Clarification Questions from first submission

# Shed floor layout

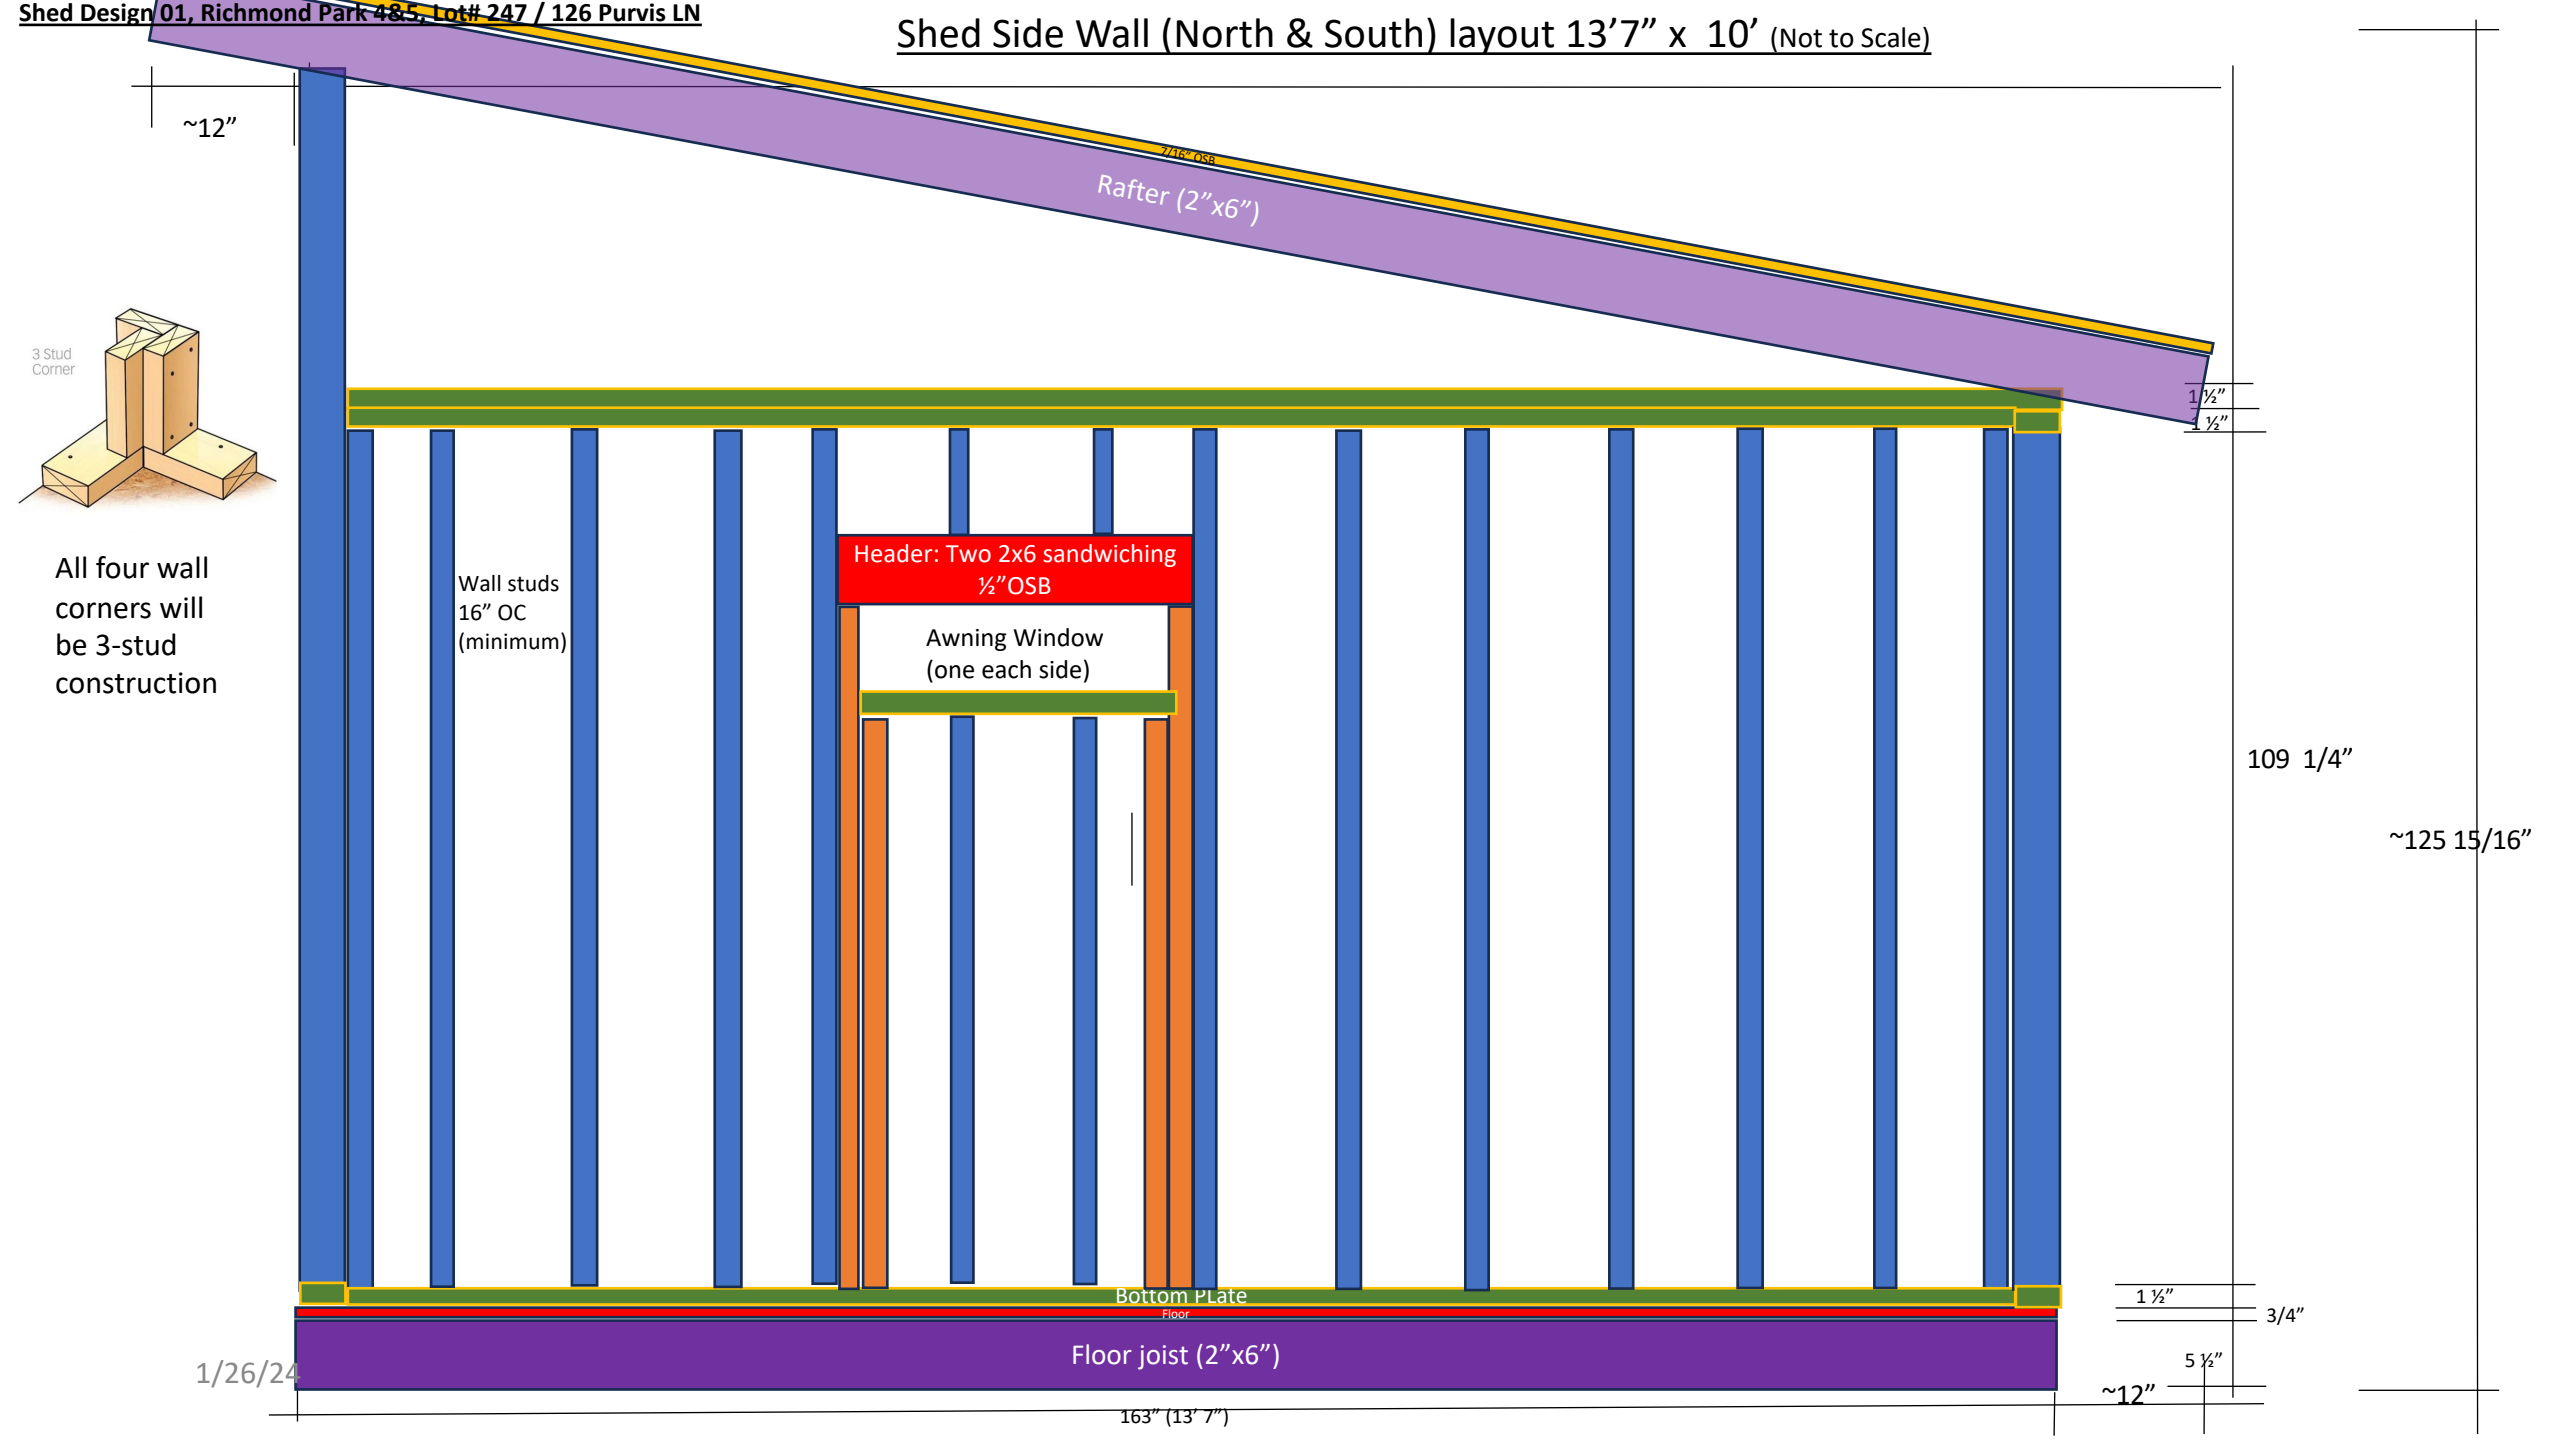
1. Floor framing size, spacing, and how floor system will be supported on gravel base?

5. Post size and spacing, post footing type, beam size, and roof pitch of lean to shelter?

Answer: Framing will be 2"x6" ground contact lumber, 16" on center. The gravel base is 3/4" washed stone bordered by ground contact 4"x6" beams bolted together and secured in place with 1/2" rebar 24-36" long.

Answer: Most information requested is covered above. 2"x6" floor joists are sitting on 5"-16" of compacted washed stone, with corners anchored with rebar and joists anchored with four hurricane anchors 30" long.

# Shed Back Wall (East) layout 13'7" x 8' (Not to Scale)

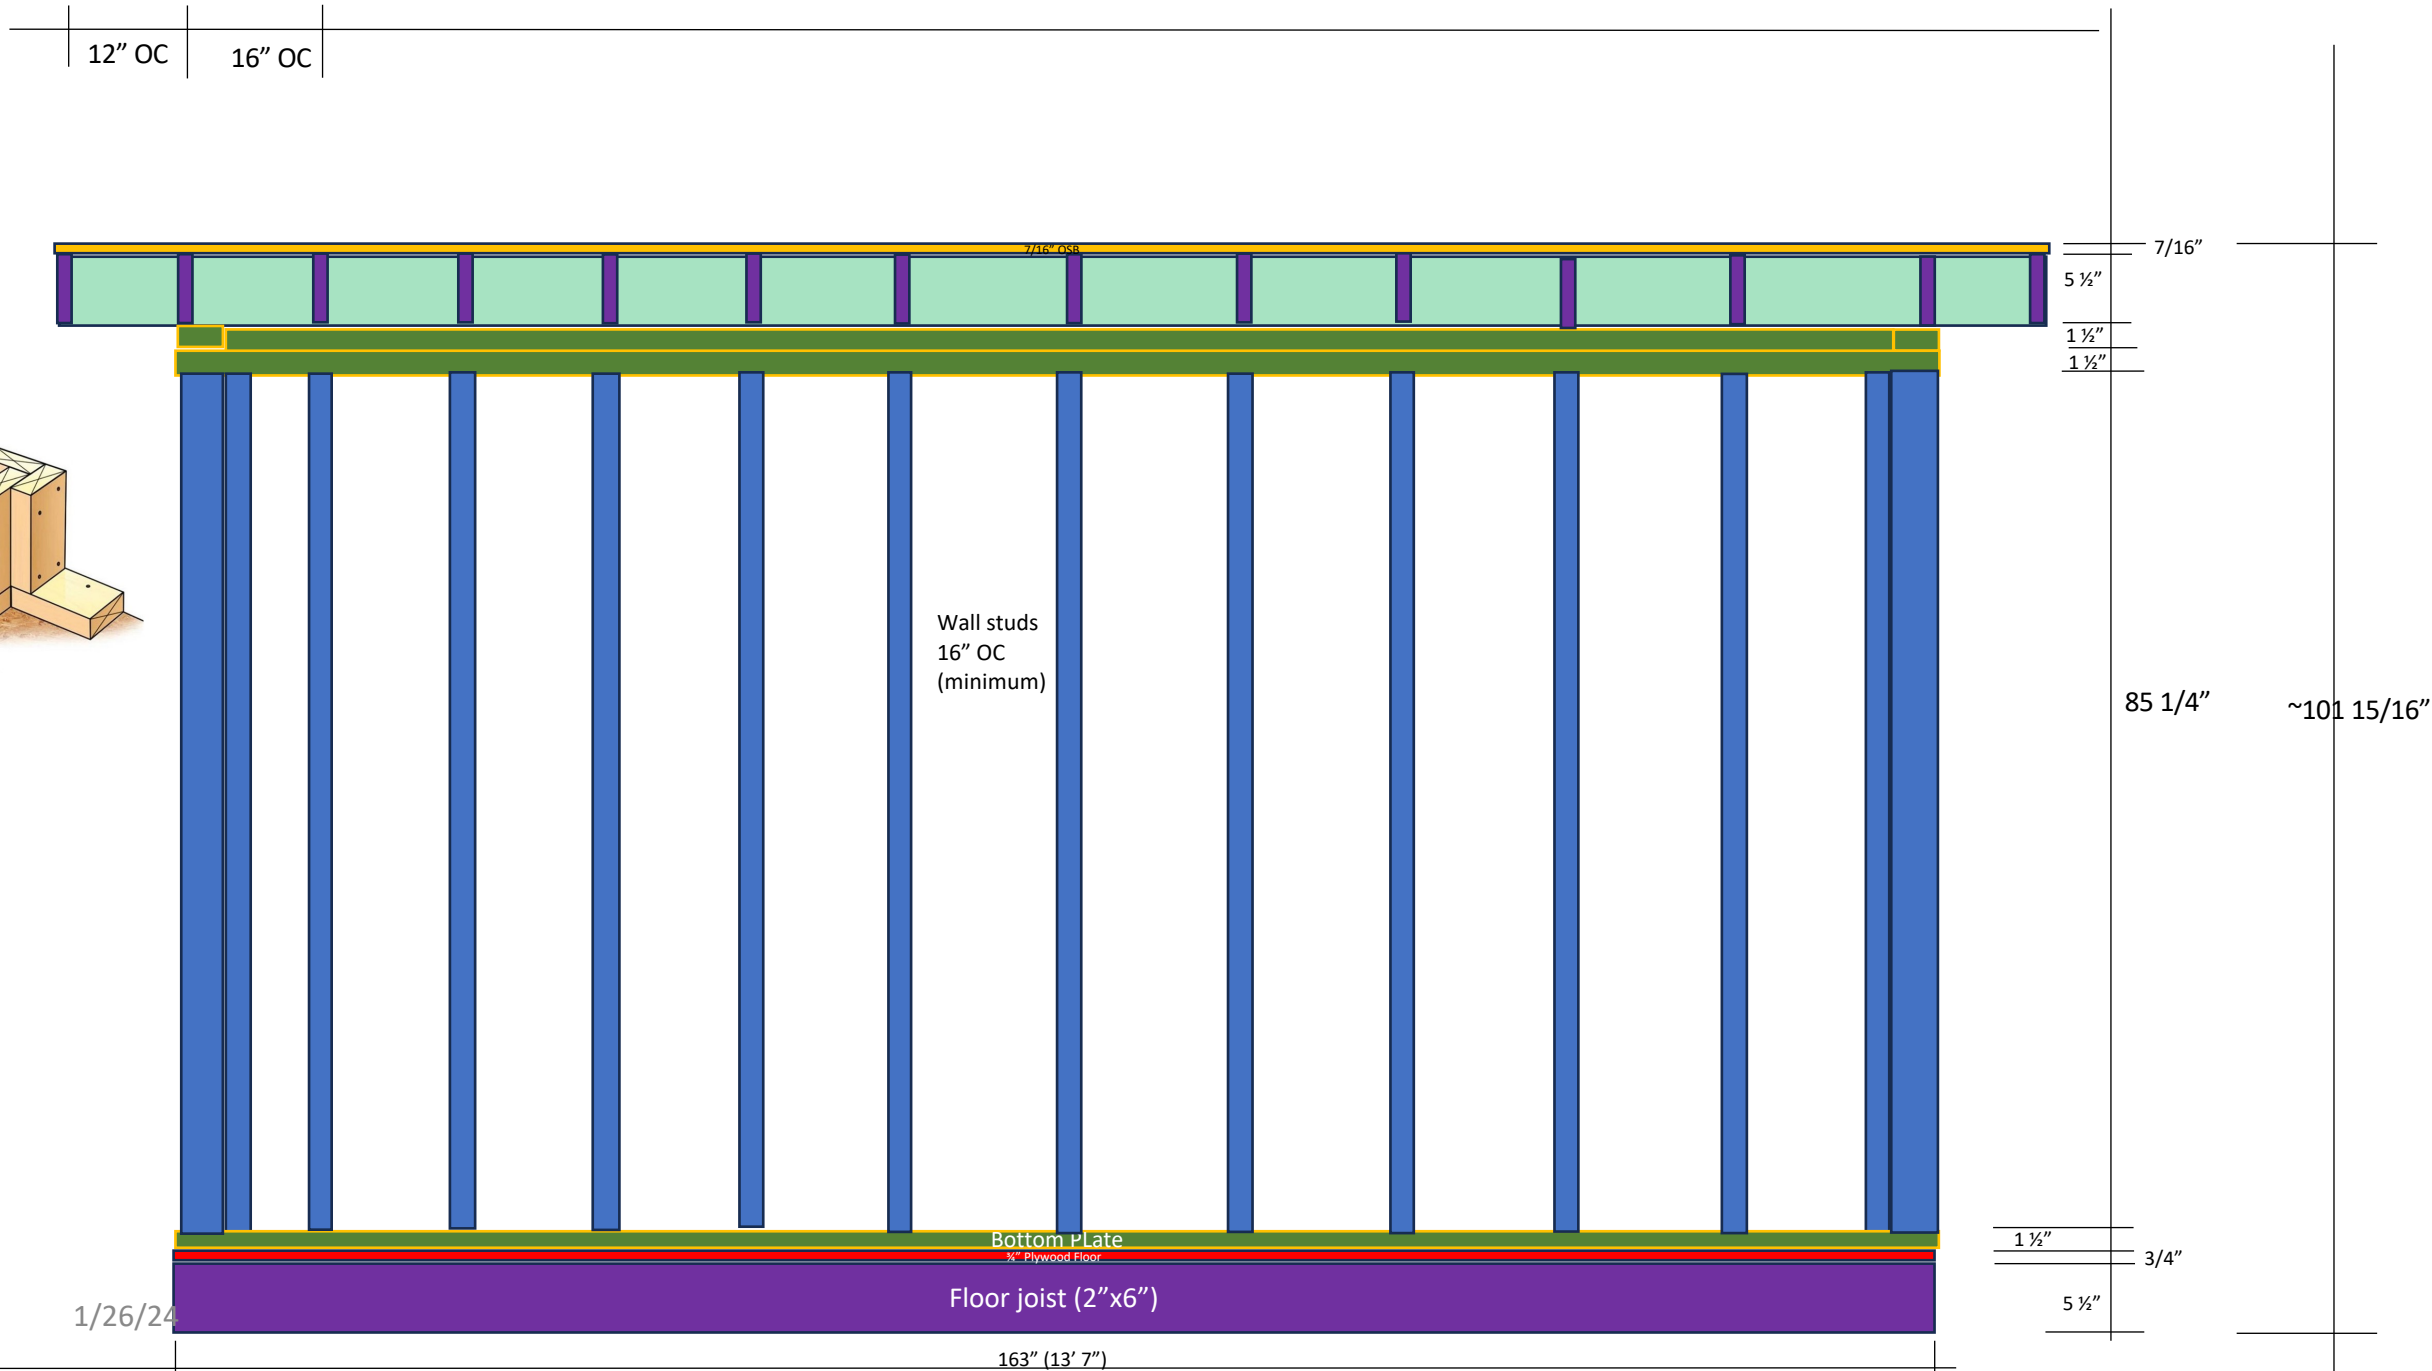
2. Wall framing details including header sizes over all openings?

Answer: Walls will be 2"x4"s at 16" on center. Bottom plates will be ground contact 2"x4". Walls will be double top plated. Headers over all windows and doors will be two pieces of 2"x6 "sandwiching 1/2" osb. Wall corners will be 3-stud construction.

# Shed Roof layout 16' x 14' (Not to Scale)

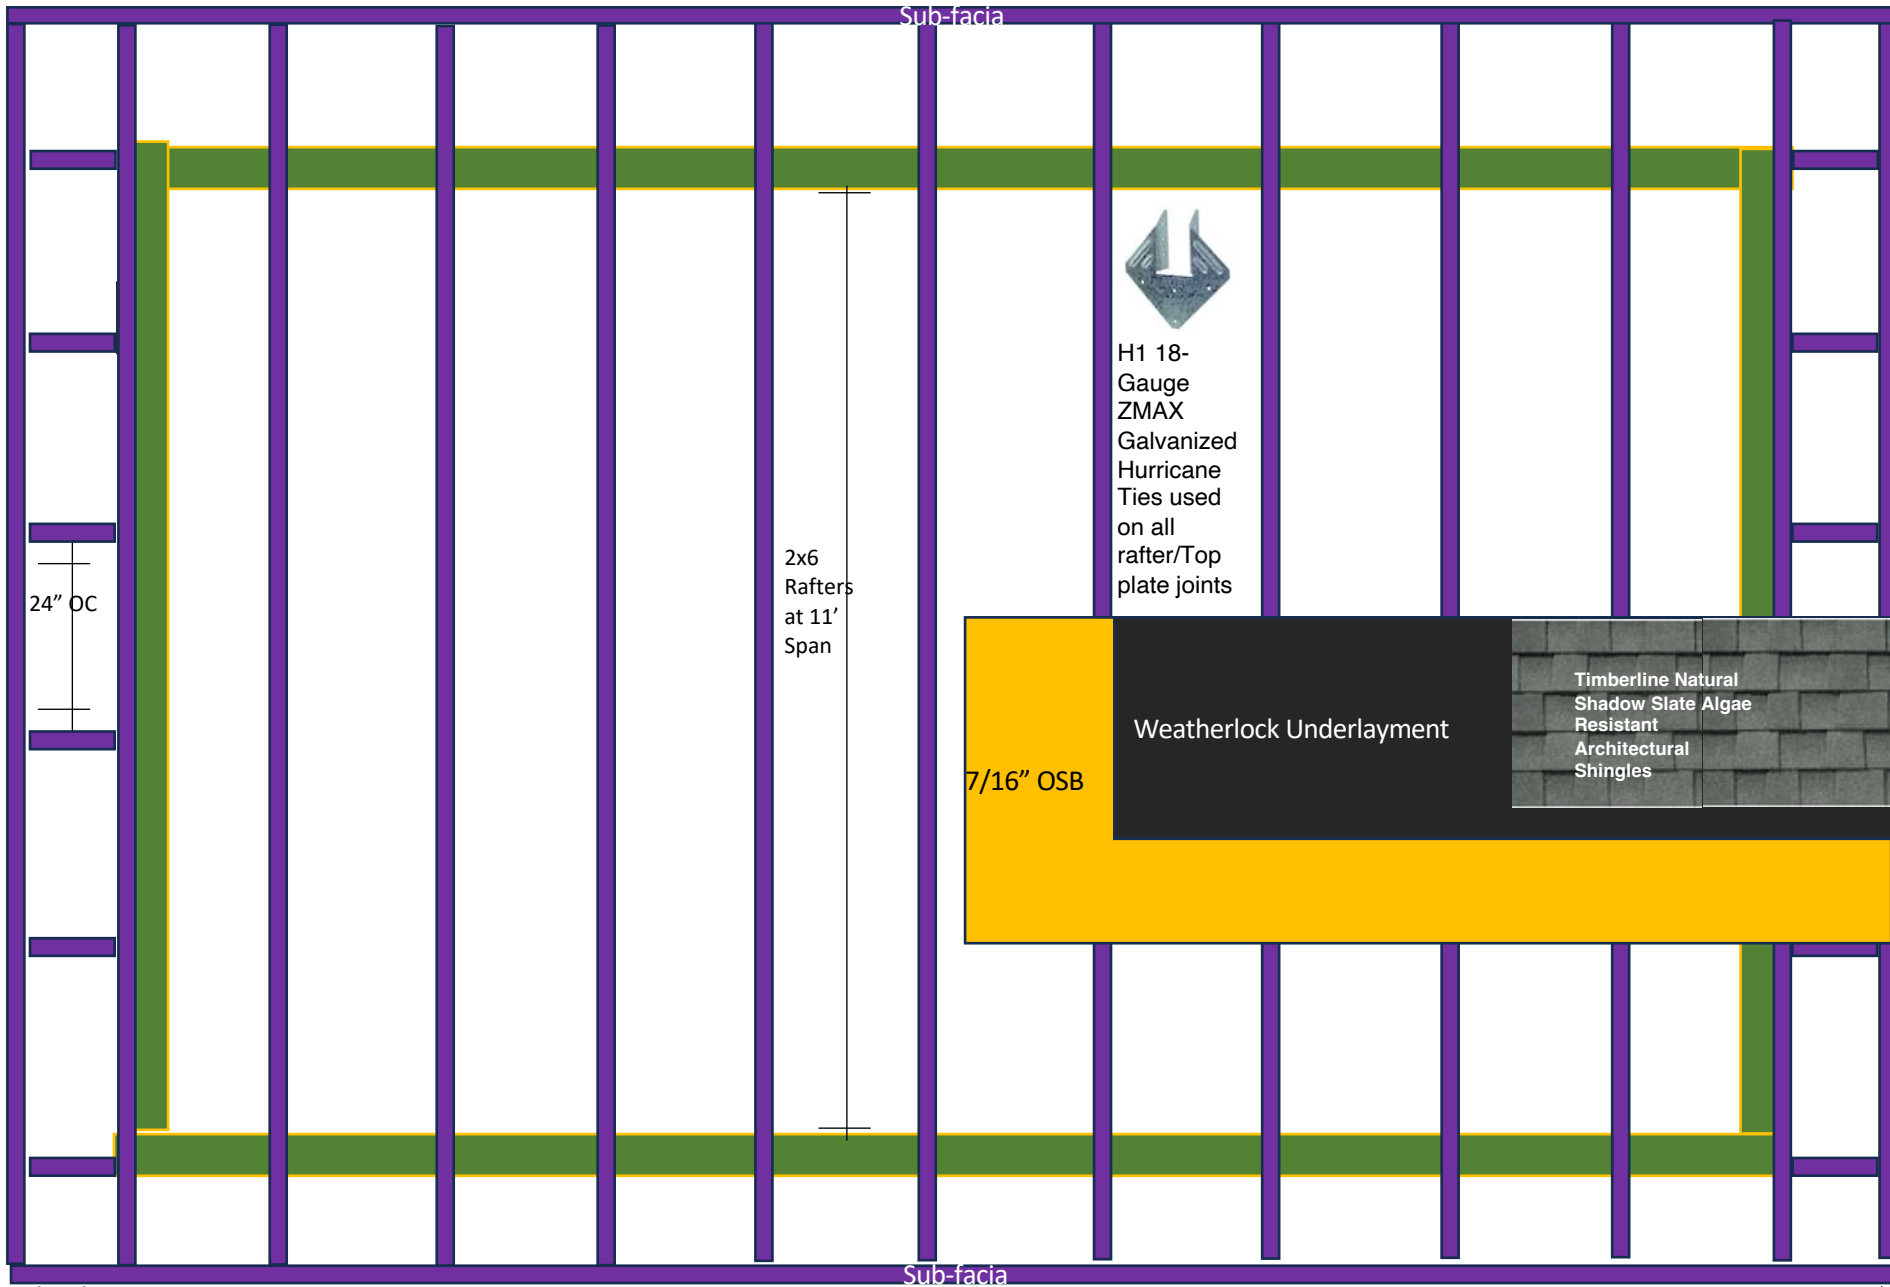
3. Roof design- size and spacing of roof and ceilings members?

4. Roof pitch and roof covering?

Answer: Roof will be a lean to at 2.5/12 pitch, using 2"x6" rafters at 16" on center. Sheathing will be 7/16" OSB covered with ice shield underlay and 25year shingles to match the house. Rafters will be reinforced with hurricane galvanized ties.
